# Rezoning Transportation Analysis

Petition Number: Zoning Petition #2021-004

General Location Identifier: Tax ID 08117410

Date	Description
02-25-2021	First Review (WB)
03-25-2021	Second Review (WB)
05-25-2021	Third Review (WB)
06-30-2021	Fourth Review (WB)

REZONING PLAN

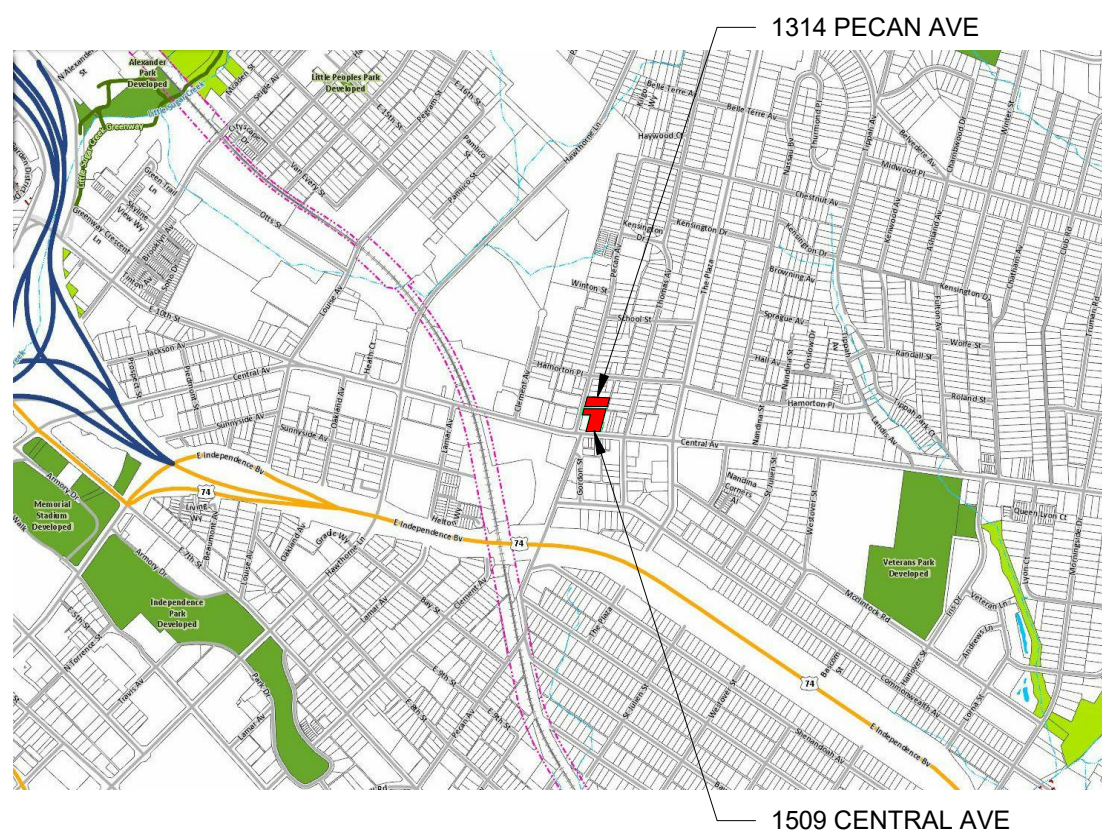
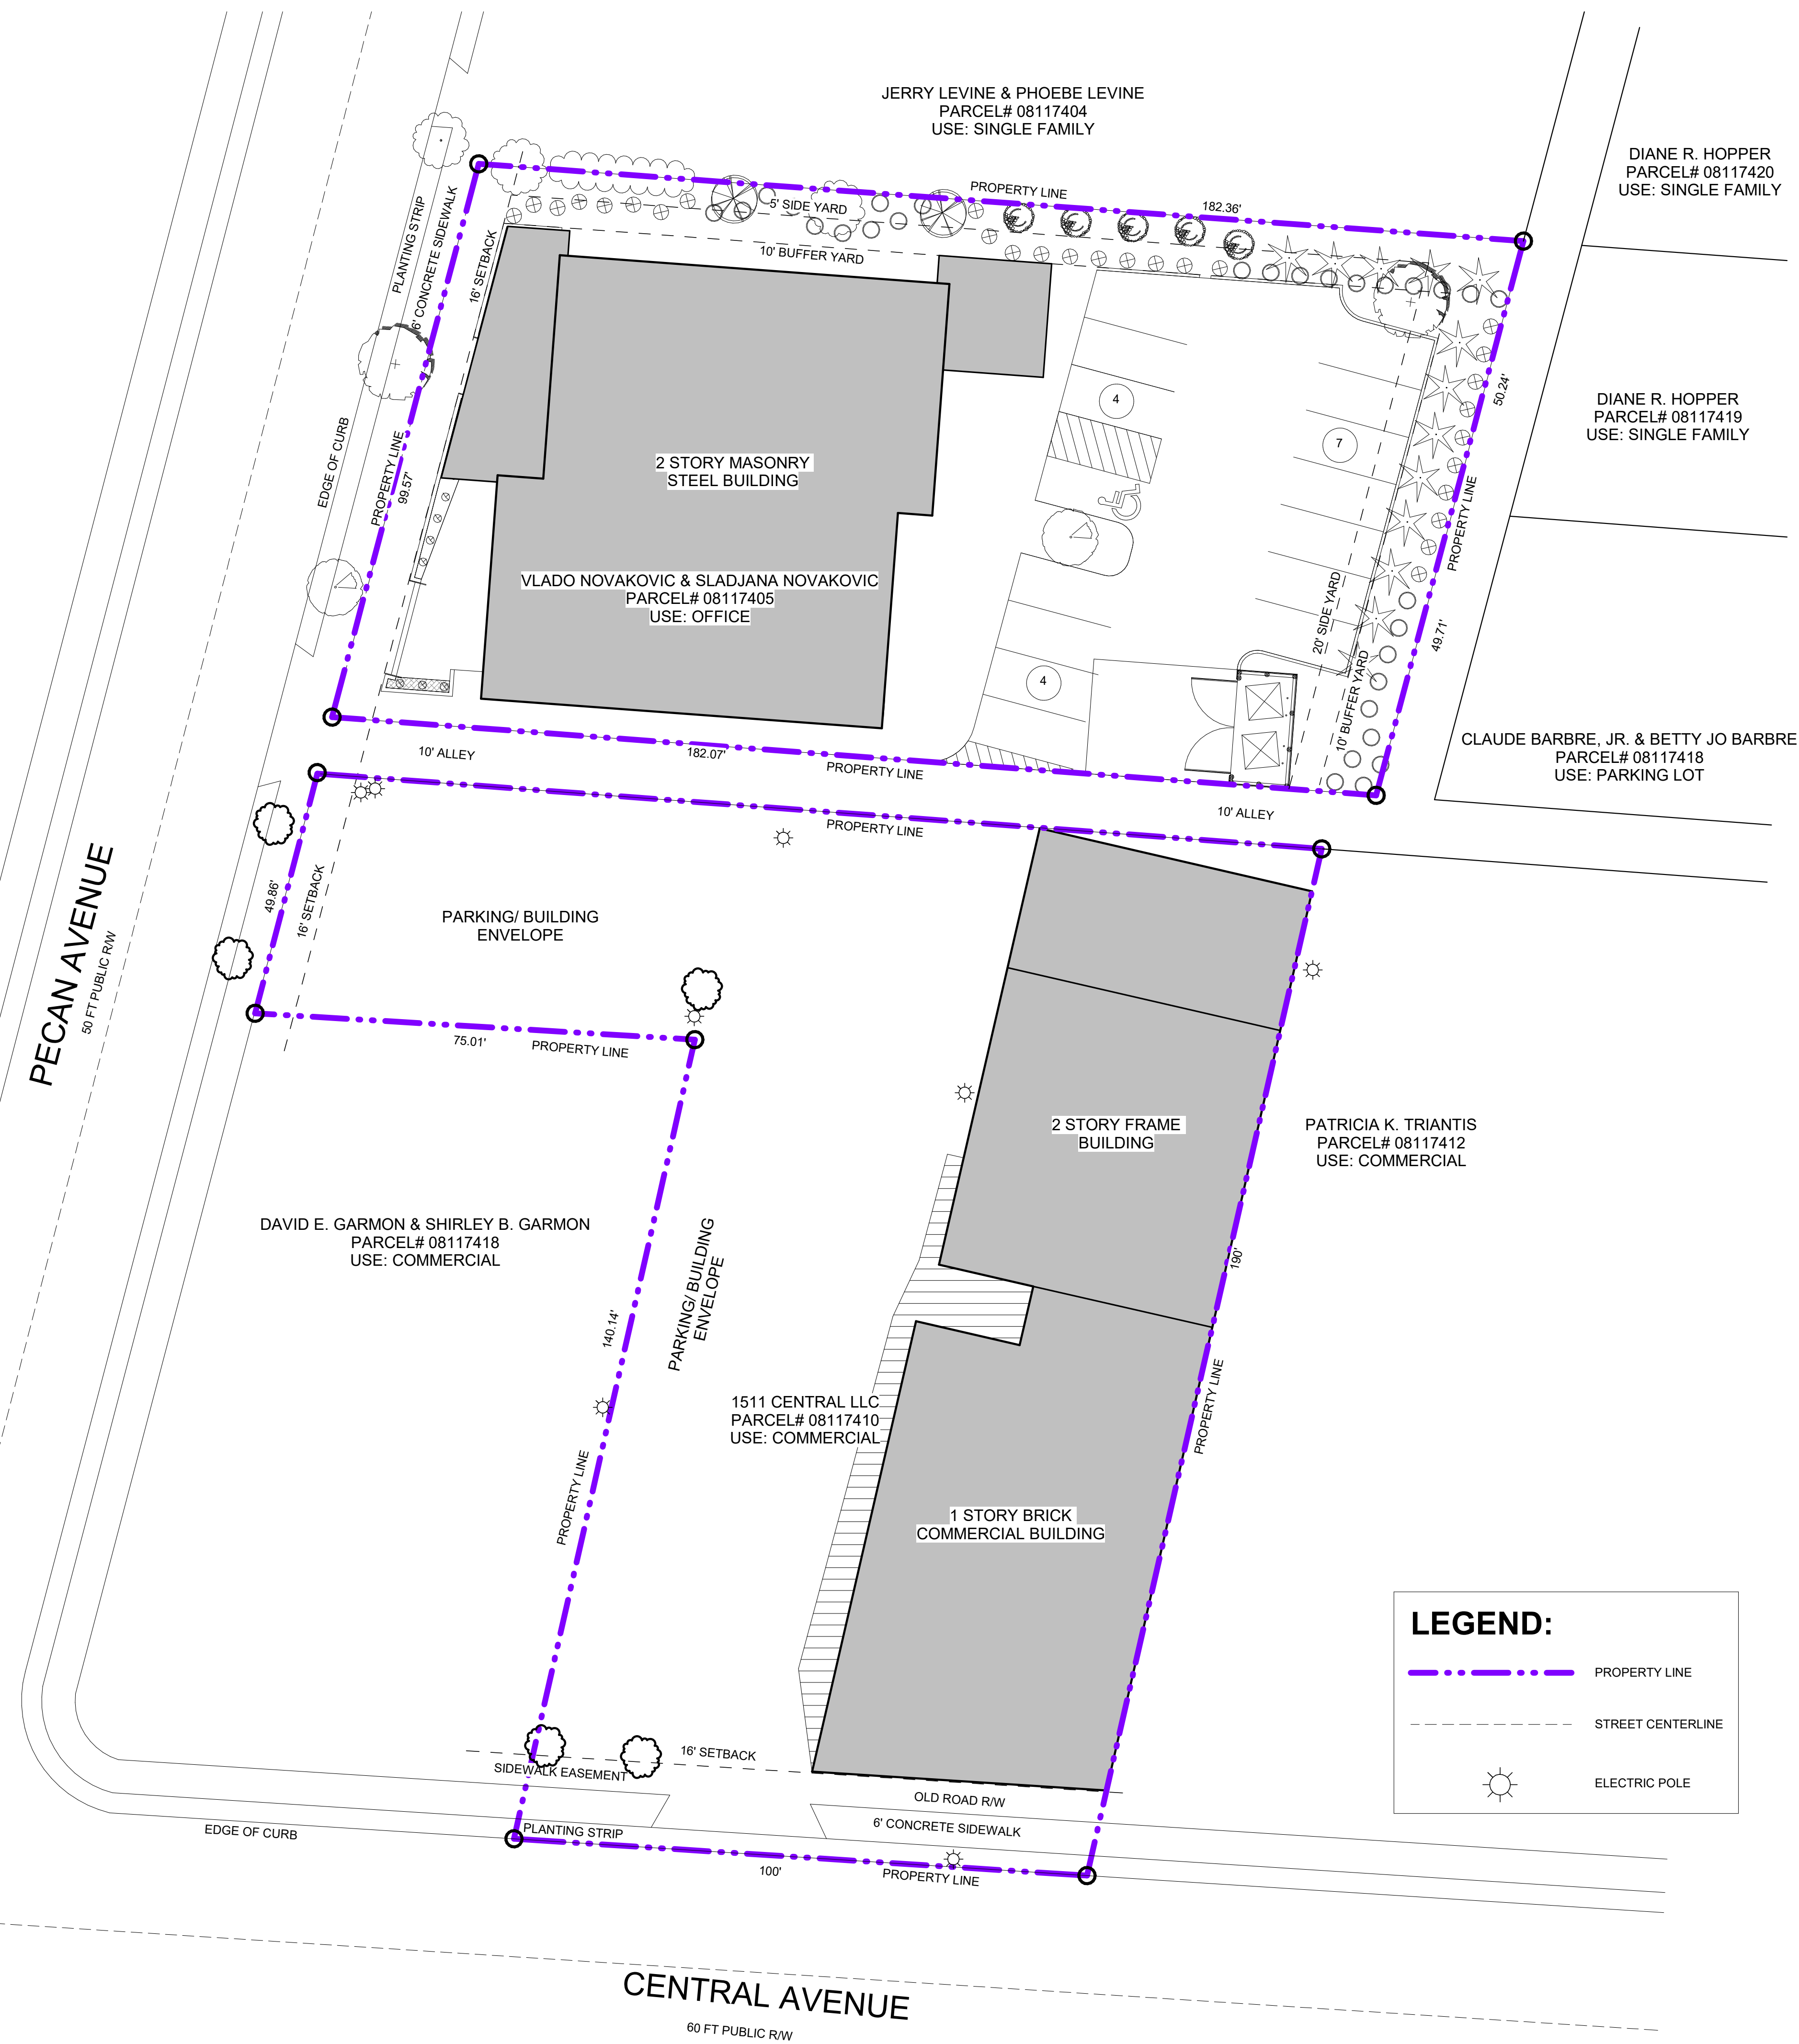
~~Label and dimension the existing curb and gutter from the centerline for each road on the site plan. **Resolved (3/15/2021)**~~

3. ~~Revise Site Conditional Note, II. Optional Provisions, to include how additional parking will be accommodated off-site, since on-street parking spaces are limited in this area. This will ensure that the existing community is not adversely impacted by parking spilling over into Pecan Avenue and adjacent streets.~~

4. ~~Revise site plan and conditional note(s) to commit to dedicating 40' right-of-way from the Central Avenue road centerline. The site plan shall label and dimension the right-of-way from the road centerline.~~

5. ~~Revise site plan and conditional note(s) to commit to providing a 15' sidewalk at the back of curb on Central Avenue, per Chapter 19 and the Plaza-Central Pedscape Plan. The site plan shall label and dimension the sidewalk from the back of curb and gutter. **Resolved (3/15/2021)**~~

6. ~~Revise site plan and conditional note(s) to commit to construct an 8-foot planting strip, and an 8-foot sidewalk on Pecan Street per Chapter 19, CLDSM U-05A and the Plaza-Central Pedscape Plan. The site plan shall label and dimension both items from the back of curb and gutter. **Resolved (3/15/2021)**~~

- ~~7. Revise site plan Conditional Note II.d. to the following: "To not require the installation of streetscape improvements along Central Avenue when change of uses or building expansions occur if Chapter 19 is not triggered. Should a future building expansion trigger Chapter 19 requirements, pedestrian and drainage facilities will be required." Resolved (3/15/2021)~~

- ~~8. Add a site plan note specifying dedication and fee simple conveyance of all rights-of-way to the City before the site's first building certificate of occupancy is issued is needed. CDOT requests rights-of-way set at 2' behind back of sidewalk where feasible. Resolved (3/15/2021)~~

- ~~9. Add a site plan note specifying that all transportation improvements will be approved and constructed before the site's first building certificate of occupancy is issued is needed. The petitioner may phase transportation improvements if said improvements and phasing are explicitly described in site plan notes. Resolved (3/15/2021)~~
